Our ref: St Philip's Christian College, Cessnock campus (SSD-10360337)

Subject: Response to Submissions

The exhibition of the development application for the alterations and additions to St Philip's Christian College, Cessnock campus (SSD-10360337) including the Environmental Impact Statement ended on 16 March 2022.

LONGITUDINAL SECTION ALONG 01
HORIZONTAL SCALE 1:1000@A1
VERTICAL SCALE 1:200@A1

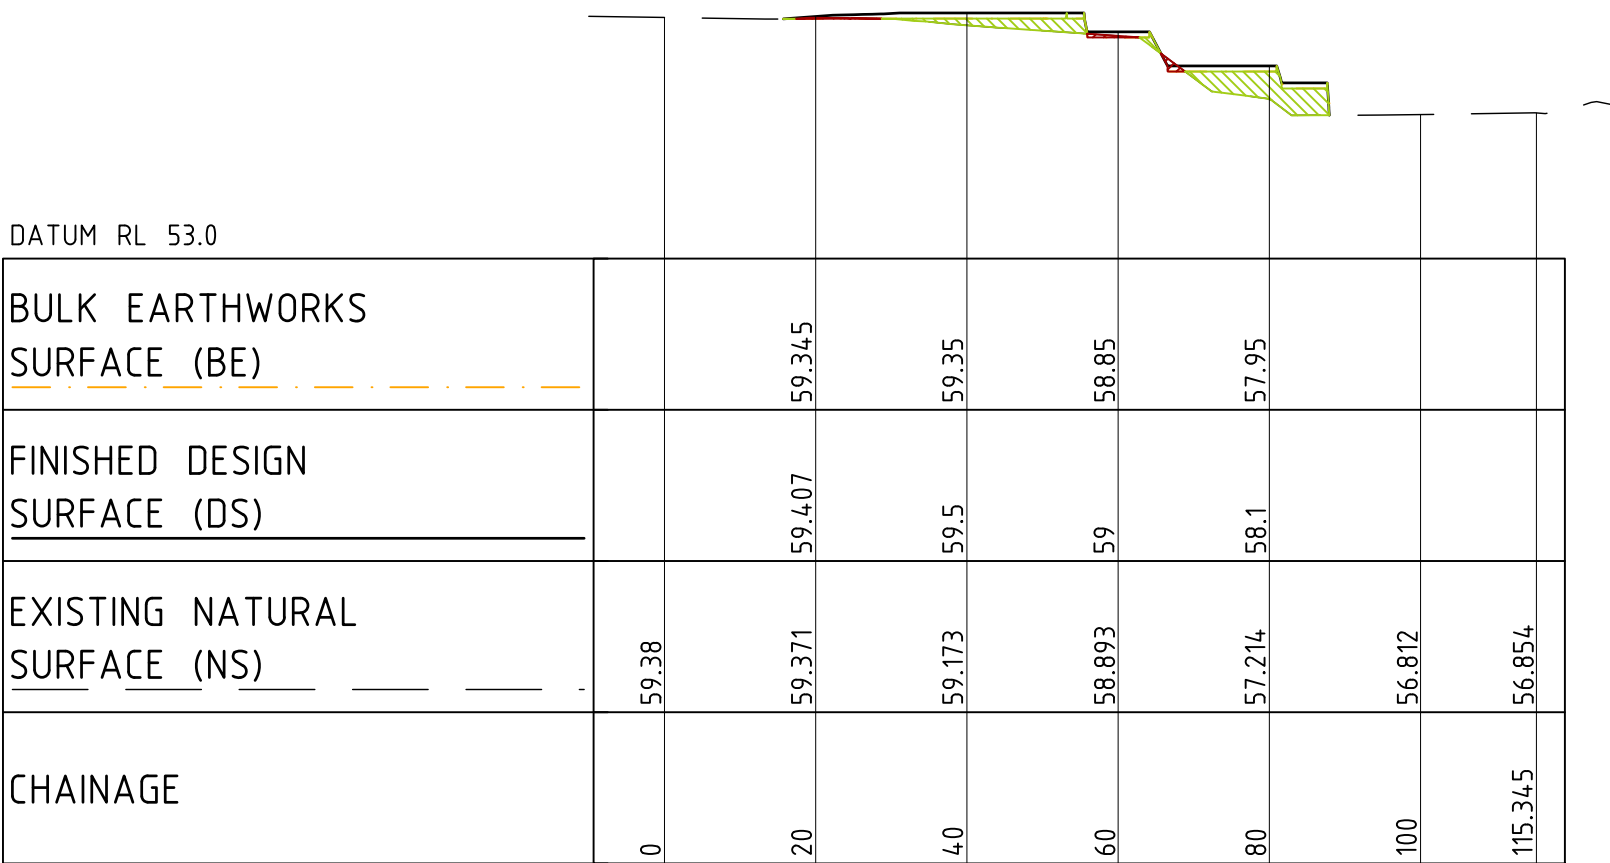
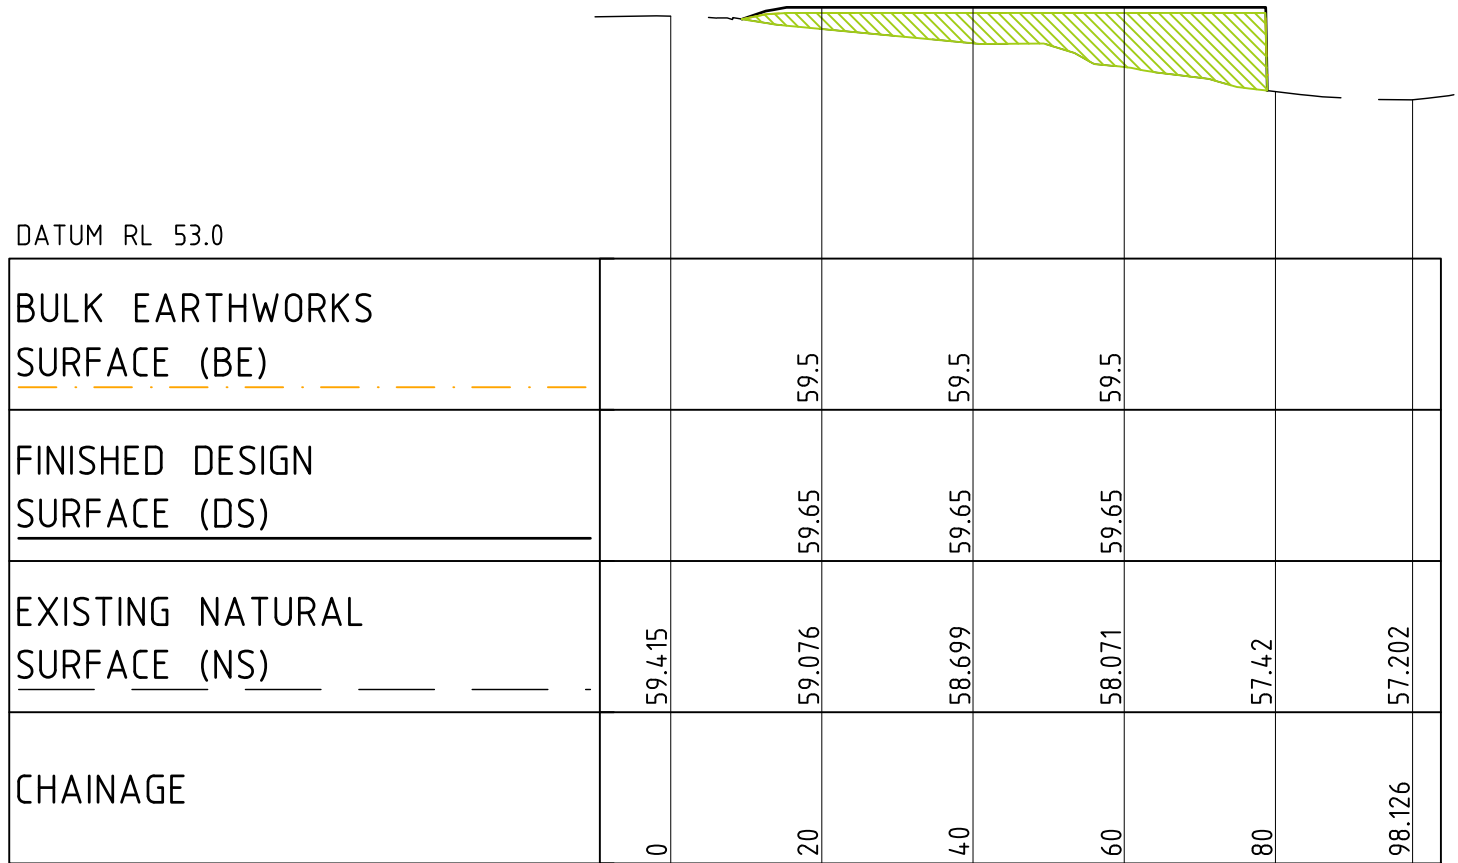
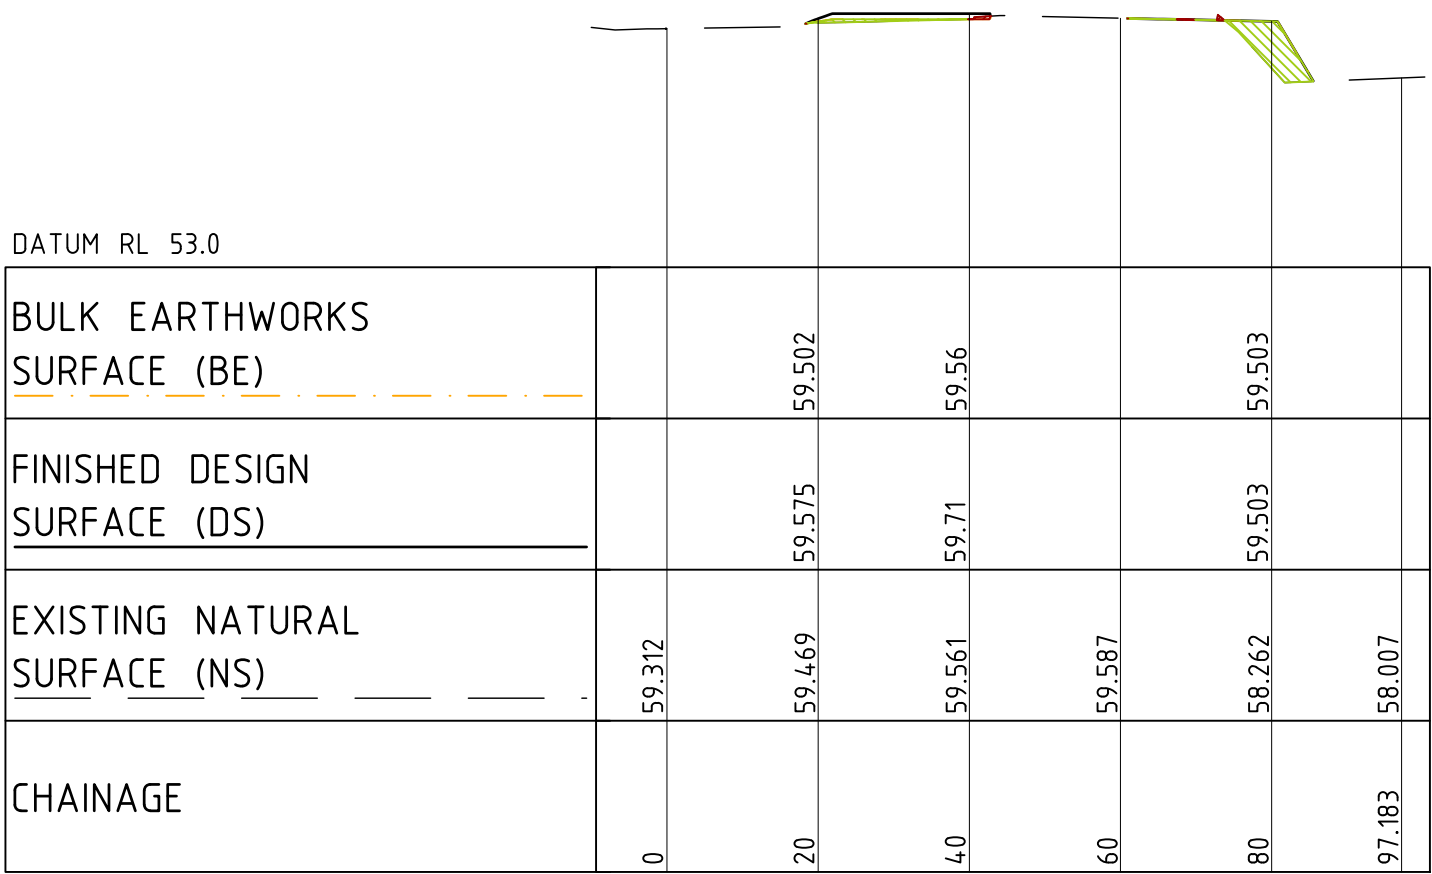
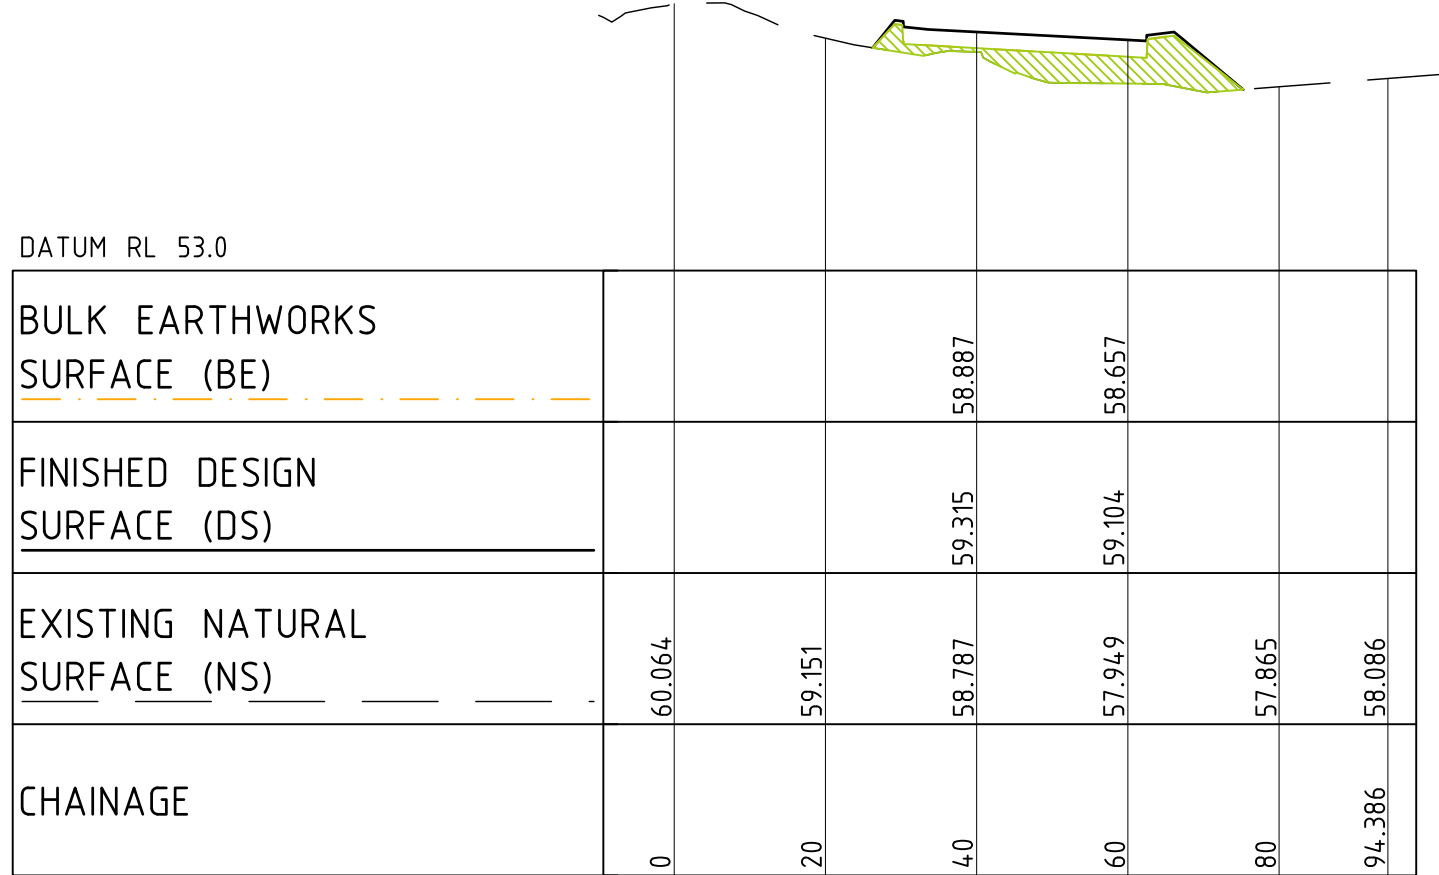
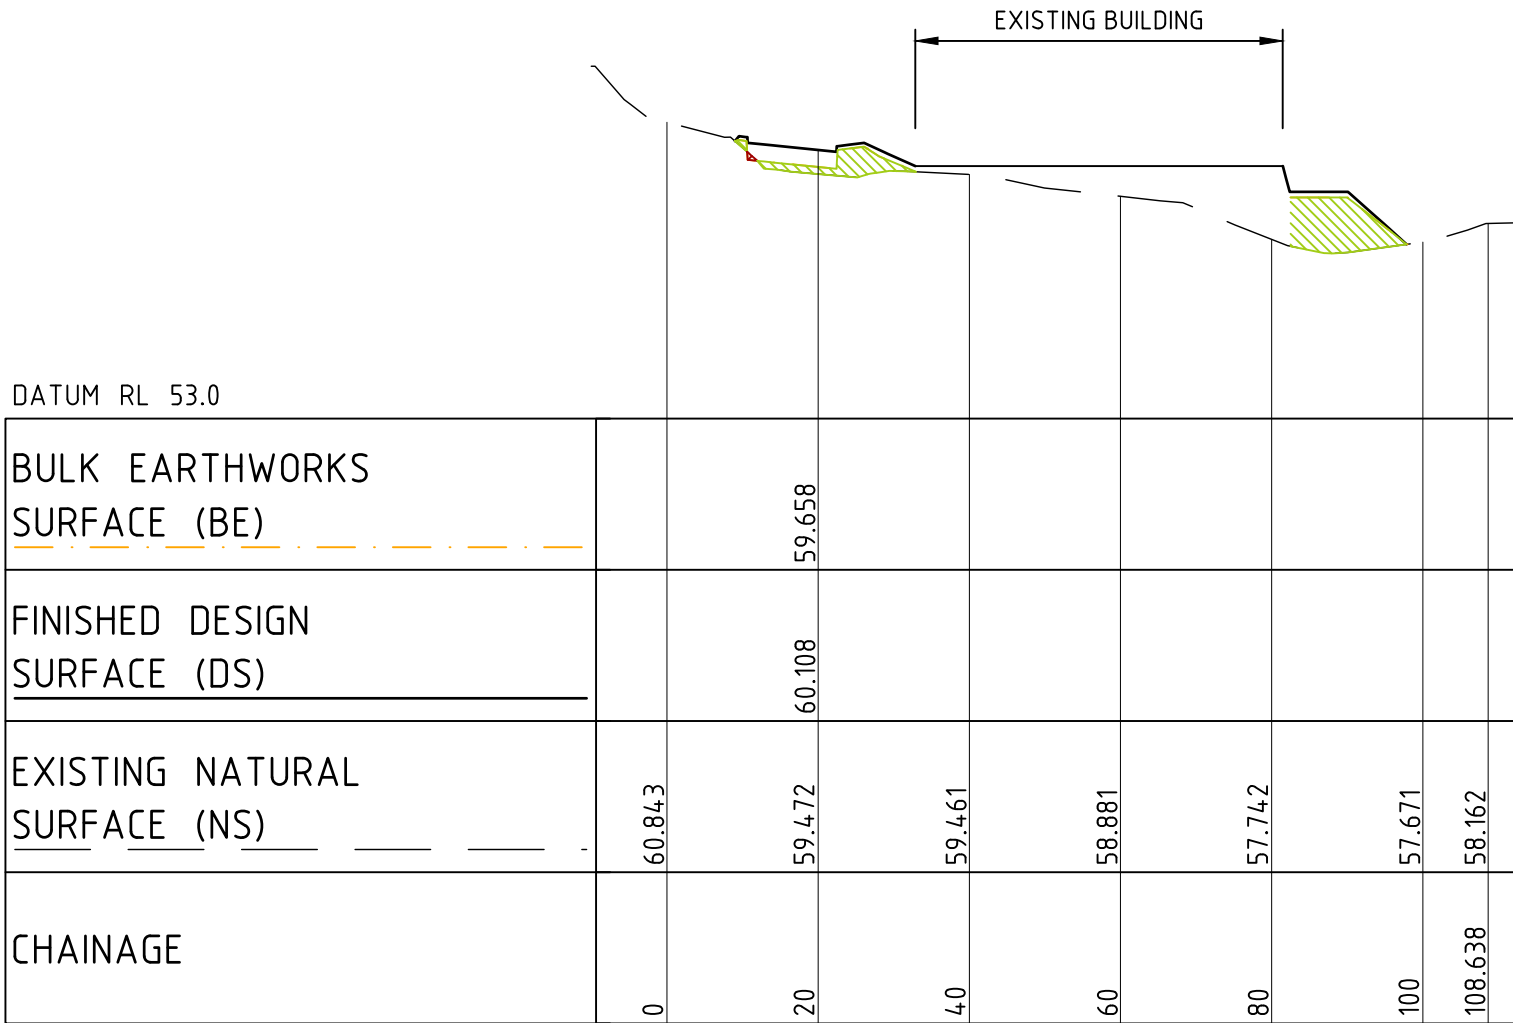
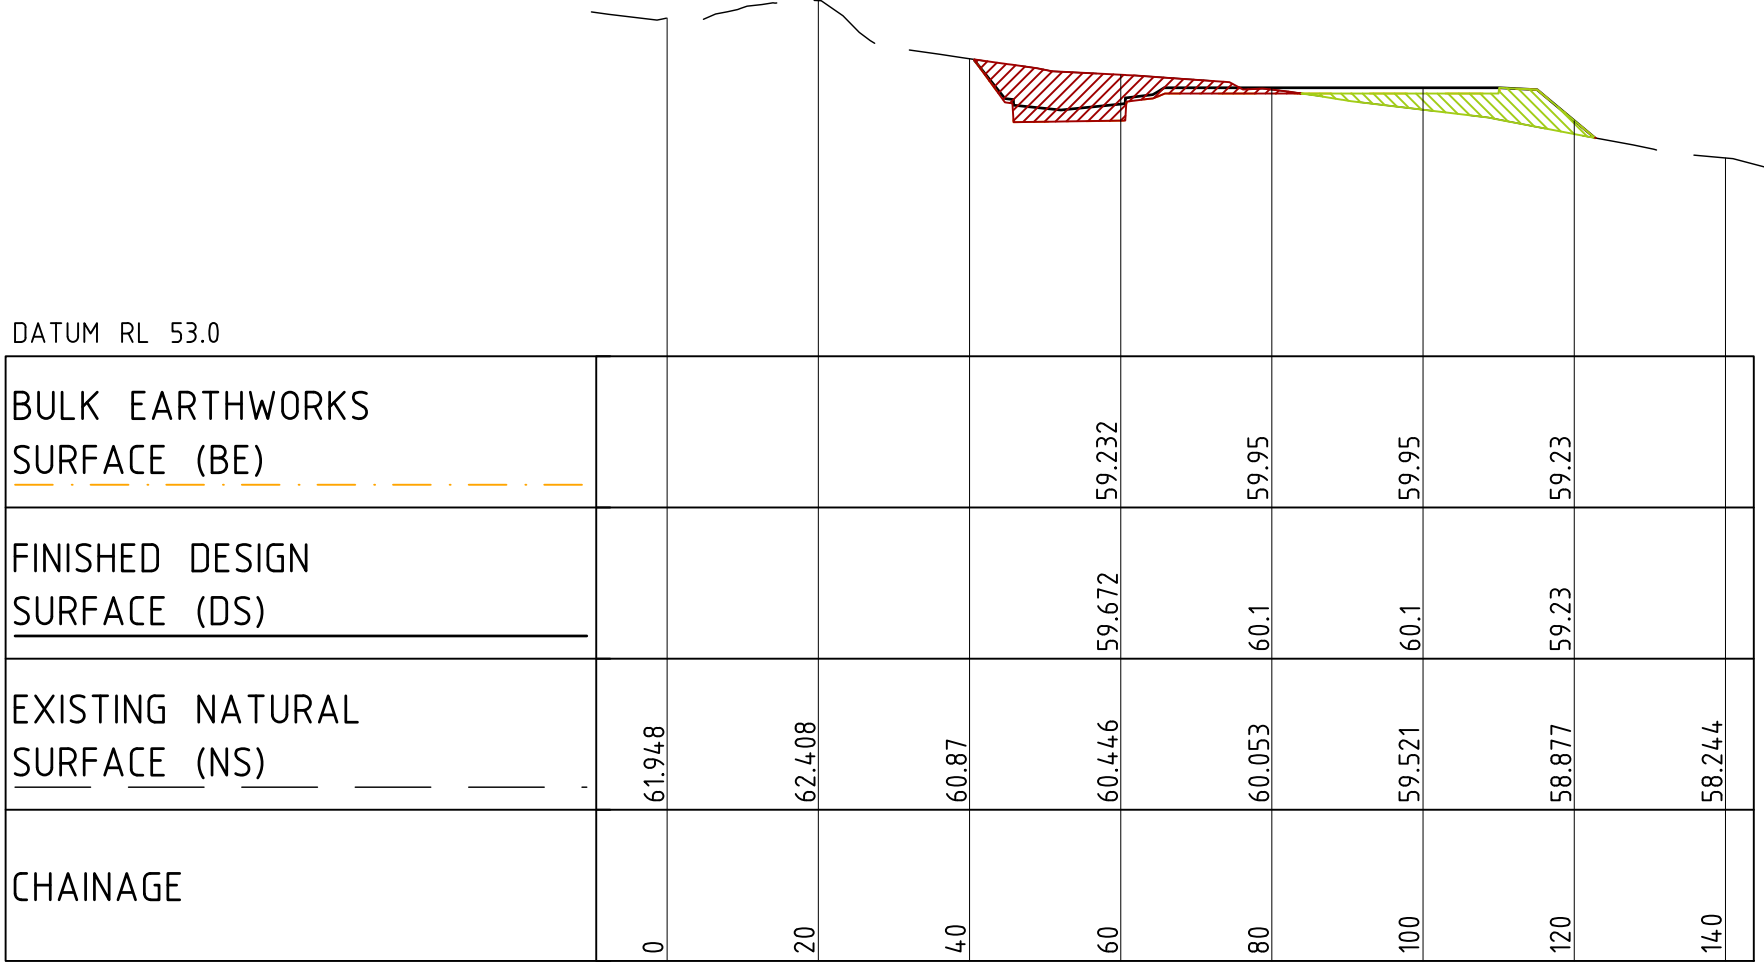
- the Concept Civil earthwork plans prepared by Northrop do not clearly depict the cut and fill across the site. The single colour scheme used to identify the sliding scale of cut vs fill needs to be clearly

identifiable. This plan should also include references to the existing natural ground levels. Section plans should also be provided to identify the extend of fill in certain locations.

4347 CD3702 RevB 18.01.22 **E - Trade Training Centre - Ground Floor Plan**

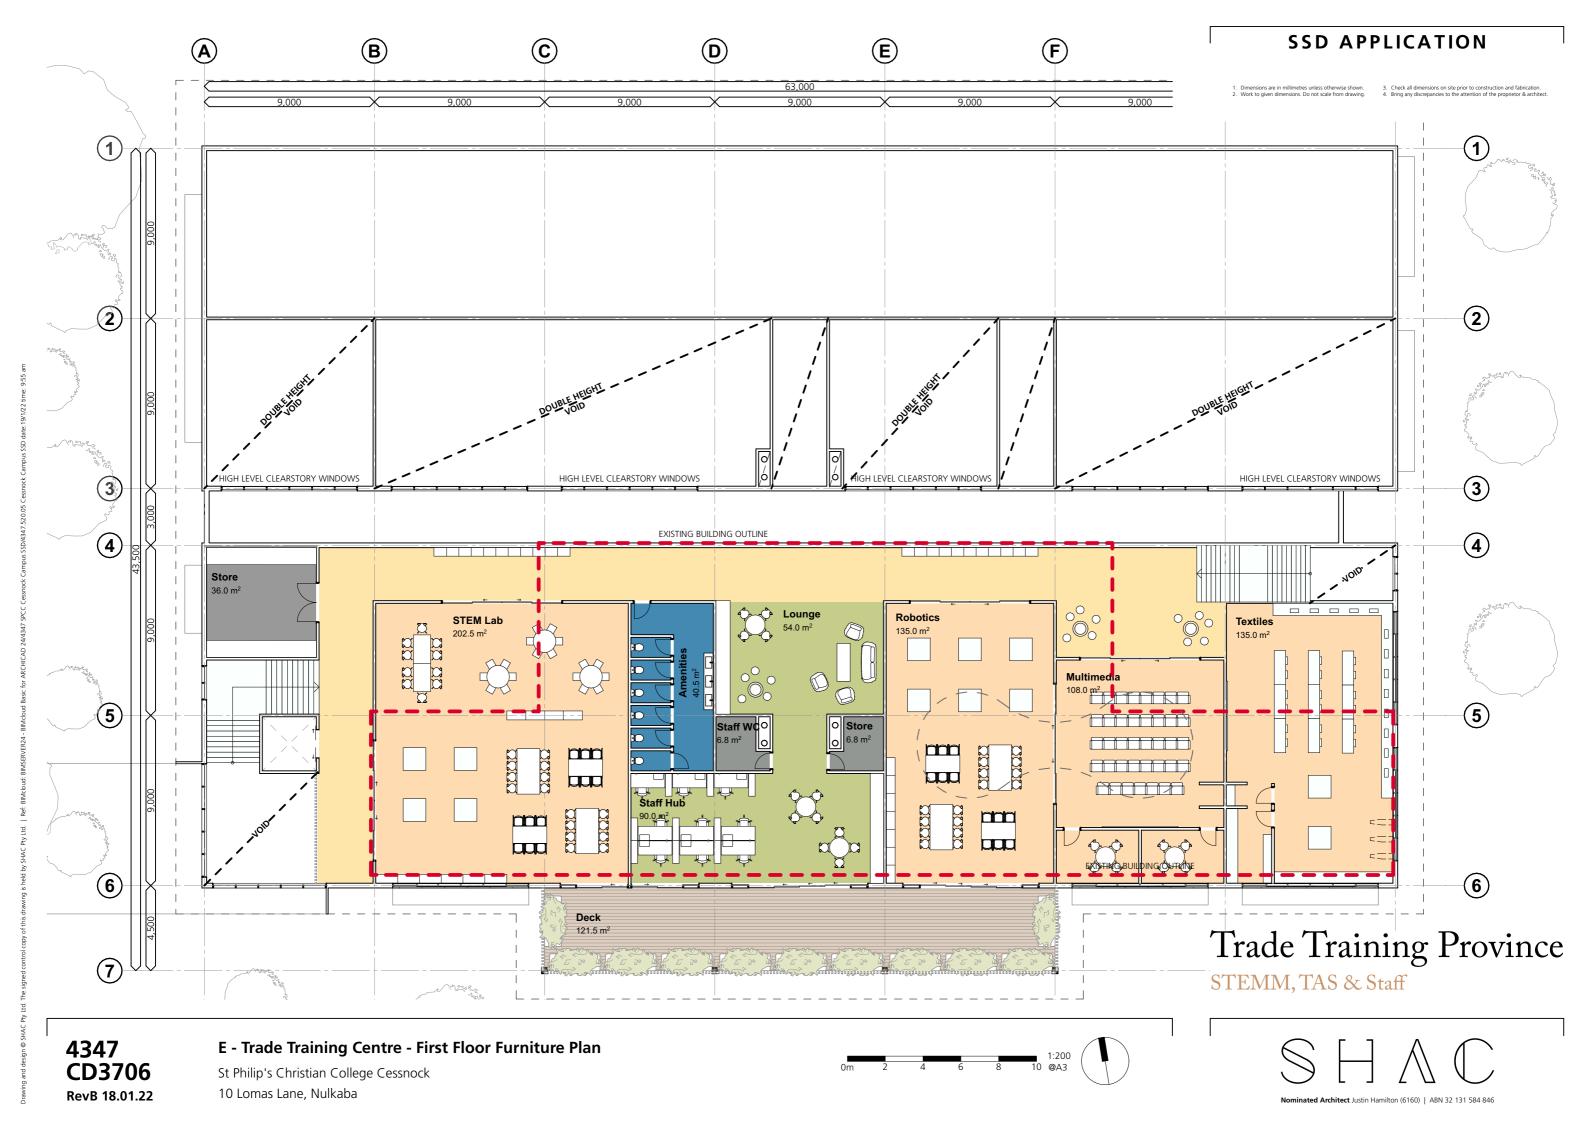
- the Trade Training Centre is proposed to increase its gross floor area (GFA) by 3710m², as stated in Table 6 of the EIS. However, page 53 of the EIS states that the Trade Training Centre building will have an overall GFA of 3710m². The Department requests you to confirm the new GFA and the total GFA for this building.
